Your Ref: BR/194/17PL

Our Ref: PE/ARU/17/26/A

Re: Promenade Opposite Clarence Road The Esplanade Bognor Regis PO21 1LX

Public Toilets

DRAWING
Proposed Toilet Elevations

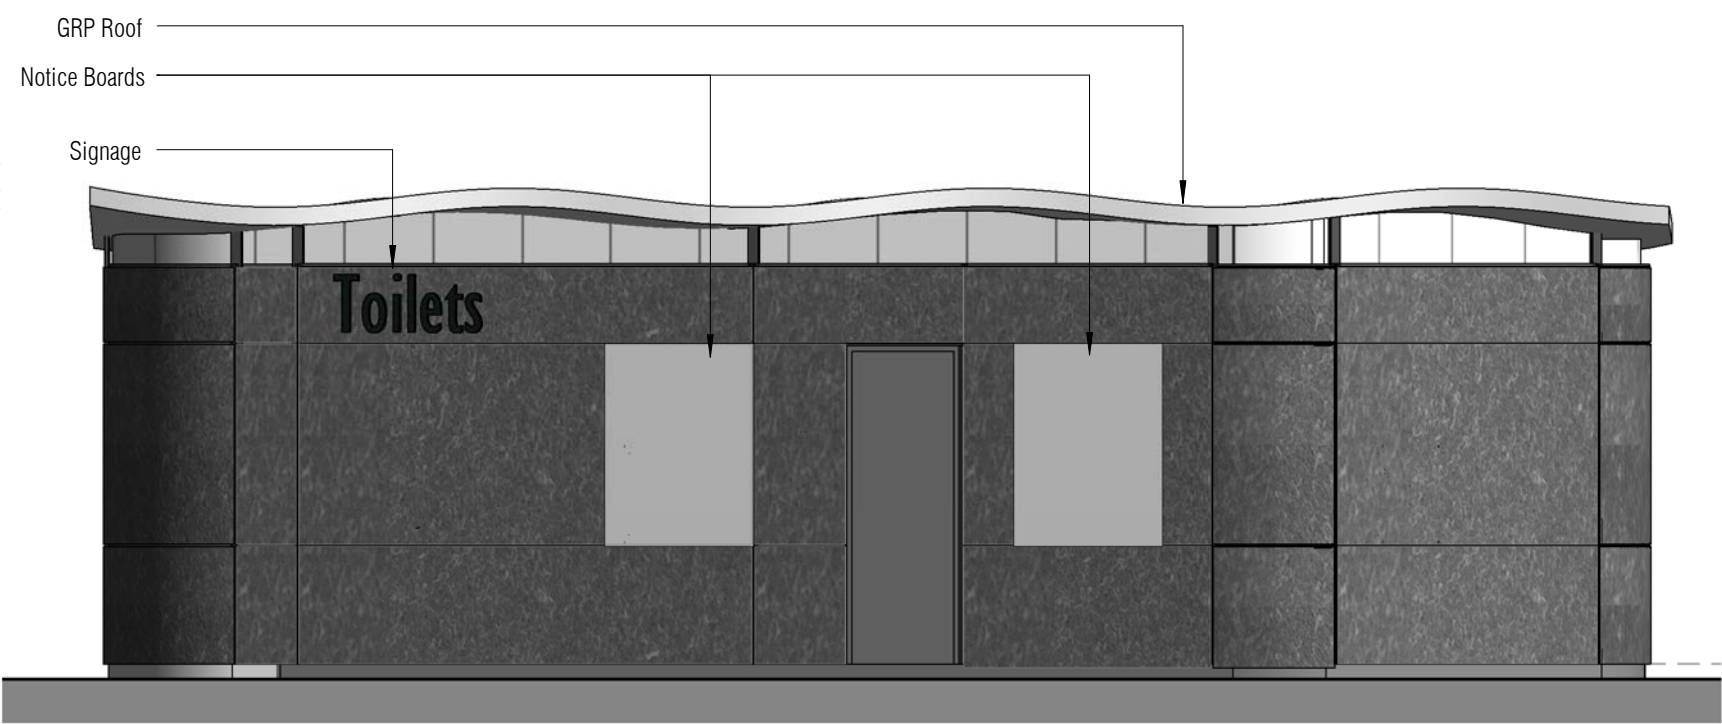
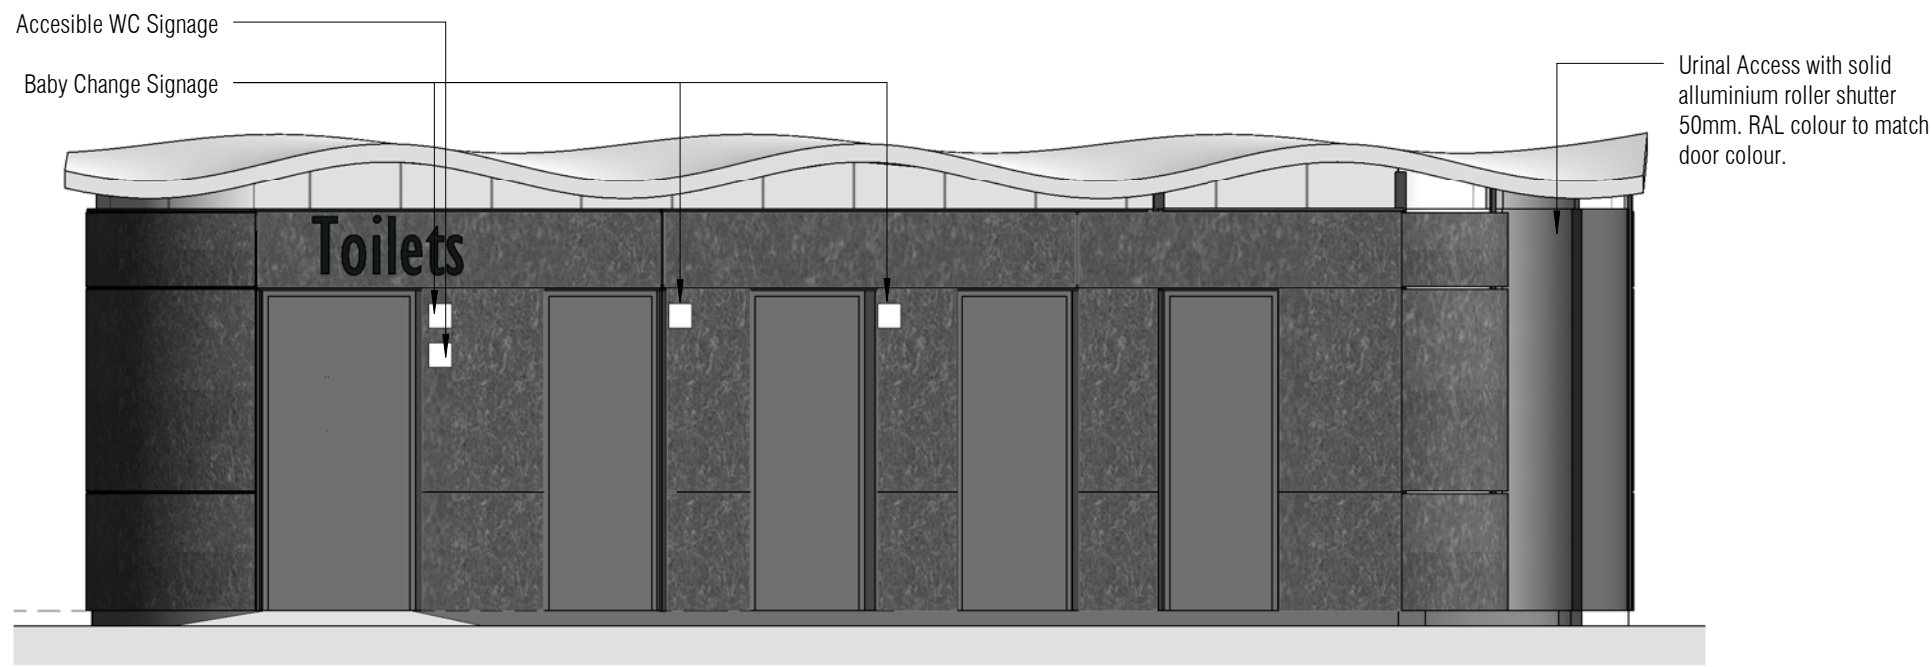
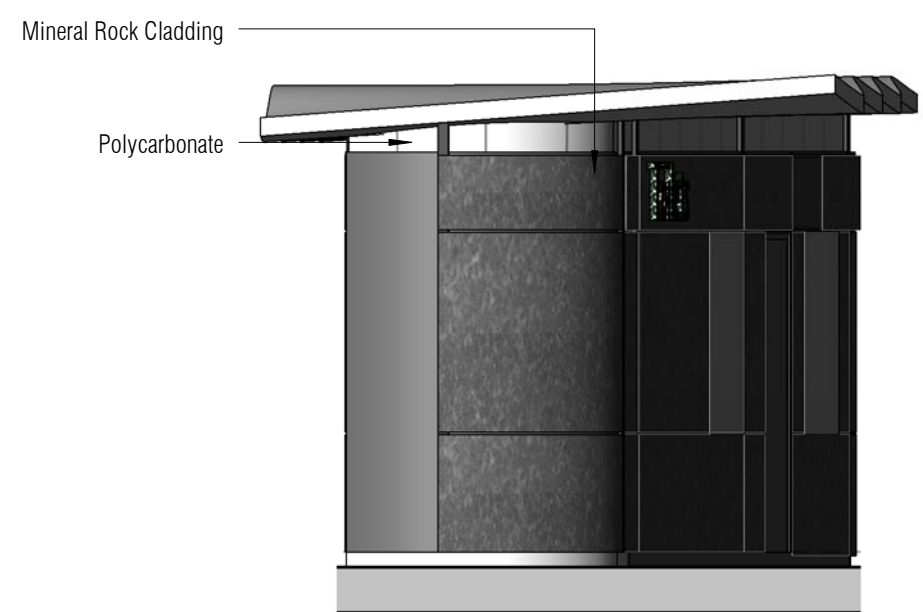
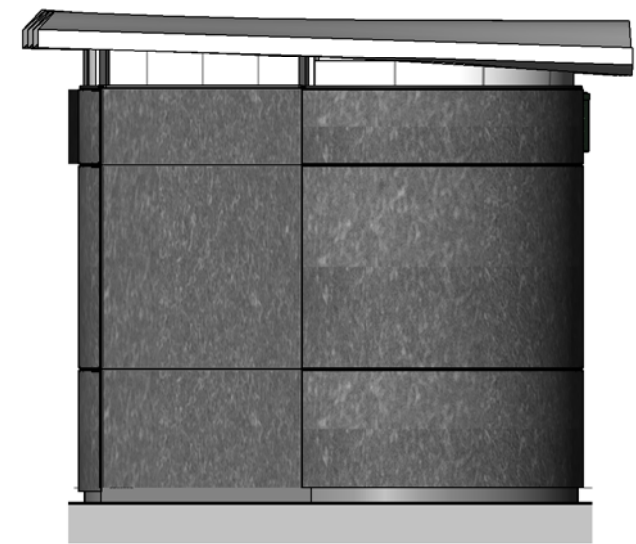
- I have concerns about the positioning of the facility, which as result causes the toilets doors to open onto the promenade's balustrade area. With the doors open, this creates a barrier blocking users in, unable to make their way back to the promenade until the adjacent door is closed. This is more apparent for the middle cubicle users

- This orientation increases the vulnerability of the users, the opportunity for robbery, assault and anti- social behaviour as well as the fear of crime.

- Despite the design's orientation being suggested to alleviate bad weather conditions impacting upon the users, I recommend that the orientation be changed so that the doors open onto the promenade. This will remove the possibility of creating a blocked off area and reduce the opportunity for robbery and assault as well as reducing the fear of crime by utilising natural surveillance and the presence of capable guardians who are using the public promenade.

- Should the orientation remain the same with all doors opening in, this will remove my above concerns but will impact upon the available space inside.

- I recommend the fitting of vandal resistant dusk till dawn lighting above each door.
- I support the recommendation of the fitting of a one way viewer in the doors to ensure safe exit for the user.

- I question why one cubicle door opens in, when the others open out. This reduce considerably the space within, given it is a baby cubicle, this may impede upon the size of pram / pushchair used and create problems shutting the door.

- I recommend that vandal resistant door and windows are installed that conform to LPS 1175 SR2 with any glazing being laminated that conforms to BS EN 356 P1A.

- The mentioned accessible toilet will need to have an adequate and fit for purpose automated door system that allows access for all types of wheelchairs and mobility, and as such have appropriated door timers and door closers installed. Access to this facility will need to be managed to ensure misappropriation of the facility is removed.

DRAWING
Proposed Beach Office Elevations

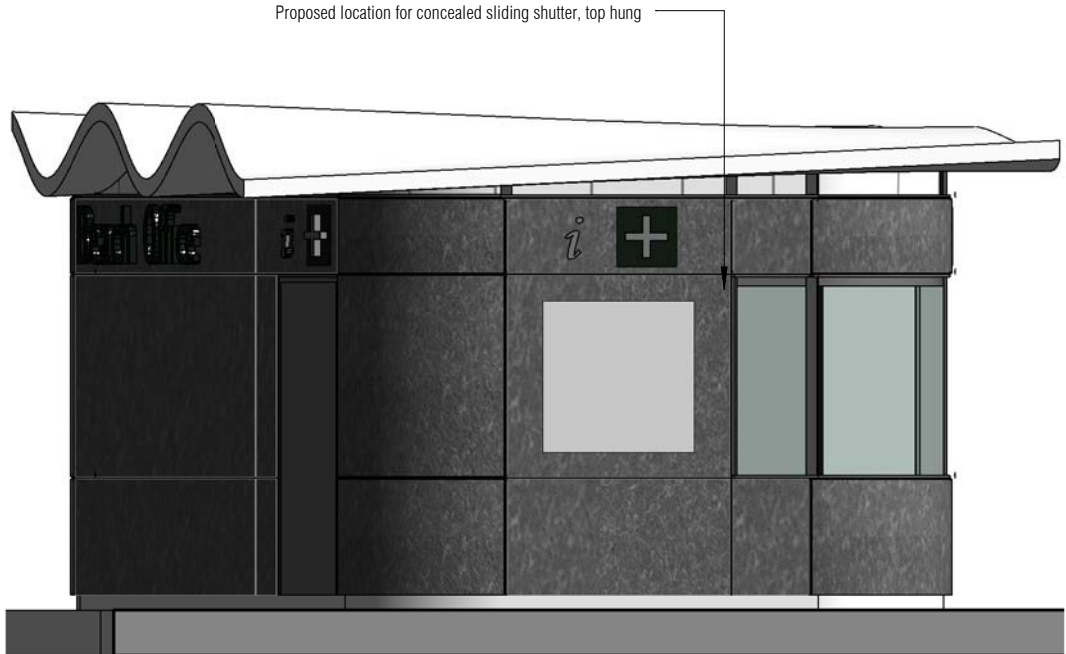
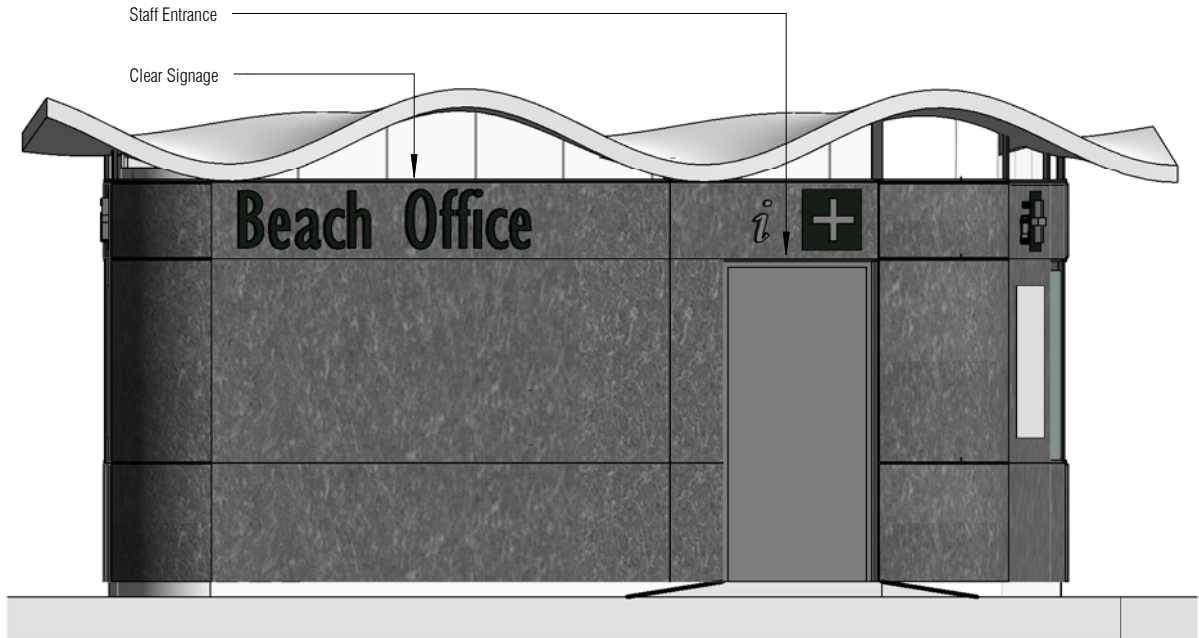
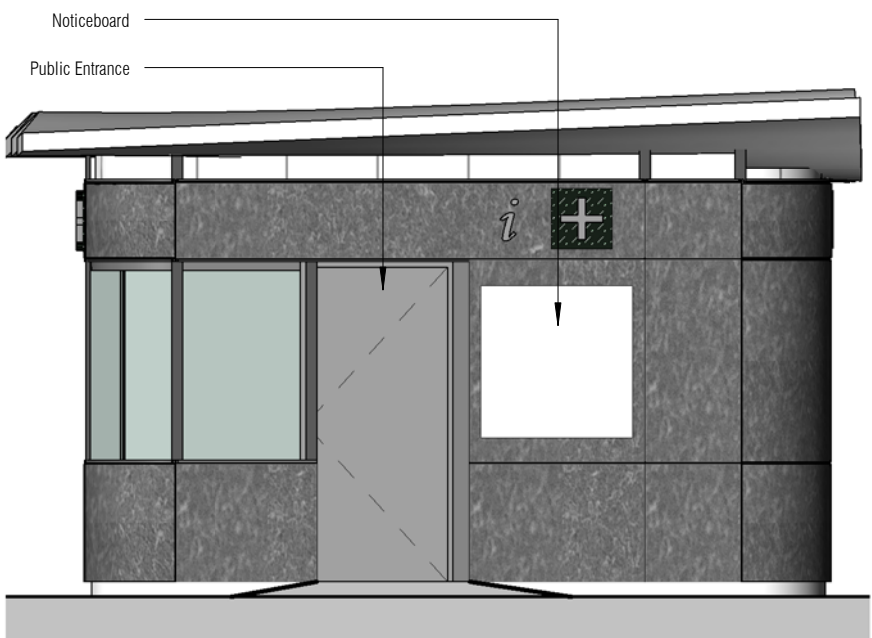
- Vandal resistant door and windows to conform to LPS 1175 SR2 with laminated glazing that conforms to BS EN 356 P1A to be fitted.
- Vandal resistant dusk till dawn lighting fitted above entry doors
- I recommend the fitting of a monitored intruder alarm within the premises to alert any out of hour's unauthorised entry.
